Our reference: EF15/2643, DOC16/250604-02
Contact: John Goodwin

SSD 7228 – SYDNEY ZOO – RESPONSE TO SUBMISSIONS REPORT

I am writing to you in reply to your invitation to the EPA to comment on the Response to Submissions (RtS) report for the Sydney Zoo project.

Figure 1 - MUSIC Layout Schematic

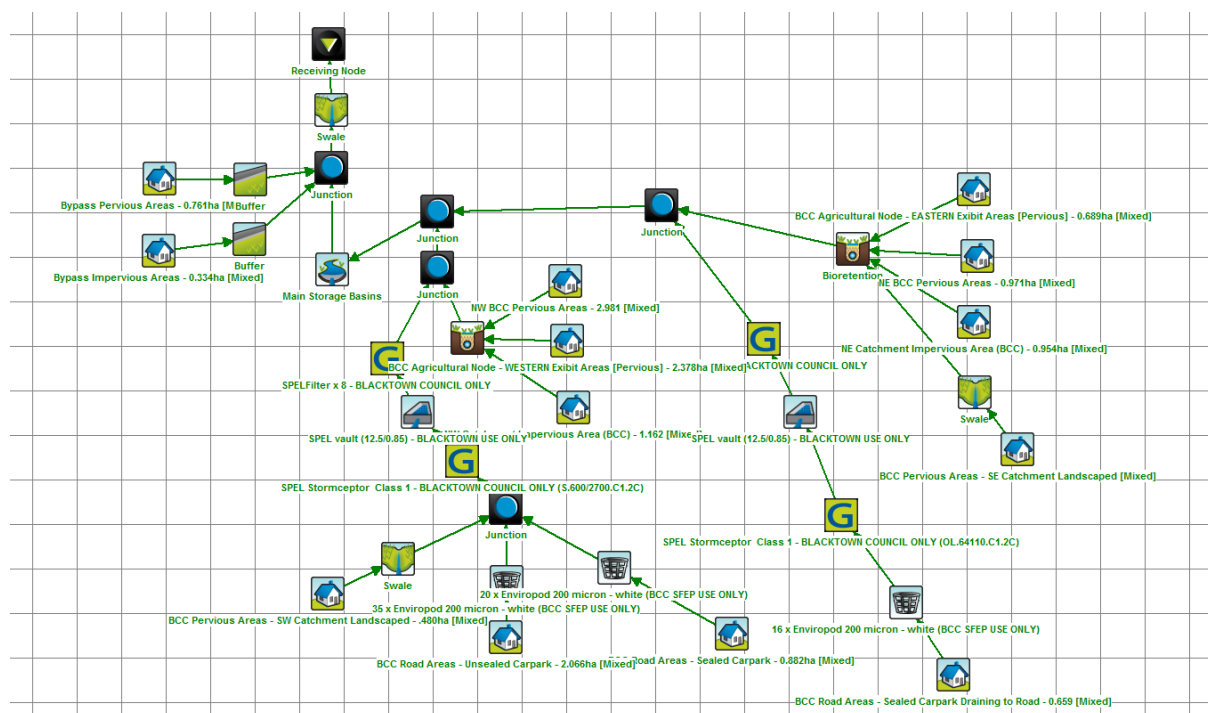
- a) provide a detailed description of and justification for the nodes and settings used in the modelling; and*
- b) discuss the underlying assumptions and limitations of the modelling when reporting the results of that modelling."*

The RtS report does not address the above recommendation. Instead, the proponent states that it "... adopted the principles for MUSIC design specified by Blacktown Council who are widely known to have one of, if not the most, stringent controls for MUSIC modelling and make their pre-approved MUSIC nodes (which differ to the default settings and as a general rule are conservative compared to default settings) available to consultants."

Blacktown City Council (BCC) may have developed pre-approved MUSIC nodes that may be conservative compared to that model's default nodes. However, the EPA is concerned that neither the BCC 'pre-approved' nodes nor the default nodes are designed to represent the nutrient and sediment generation rates for run-off from animal enclosures. And, the proponent has not presented evidence to support the applicability of its assumptions concerning the MUSIC model.

- a) BCC's recommended EMC values are much less (~90% less) than those observed by Zhou for animal enclosures, which suggests that BCC's 'pre-approved' node may significantly underestimate the sediment and nutrient generation rates for the proposed animal enclosures;
- b) a substantial proportion of the nutrients observed in run-off from the animal enclosures was in dissolved form indicating that treatment measures would need to be designed and managed to specifically treat dissolved forms; and
- c) elevated Chemical Oxygen Demand (COD) was observed in run-off from animal enclosures, indicative of entrained organic matter that can cause oxygen depletion in aquatic environments, which suggests proposed treatment measures would need to be designed and managed to specifically treat organic matter.

The EPA considers that where modelling is used to demonstrate treatment system performance, the proponent should:

- identify all assumptions underpinning that modelling;
- provide adequate justification for the adopting the assumptions underpinning that modelling, and
- provide a detailed analysis that properly addresses key model limitations.

Similarly, the EPA considers that relevant empirical data such as that available from the scientific literature should have been used to inform estimates of pollutant concentrations (i.e. node EMCs) associated with animal enclosure effluent.
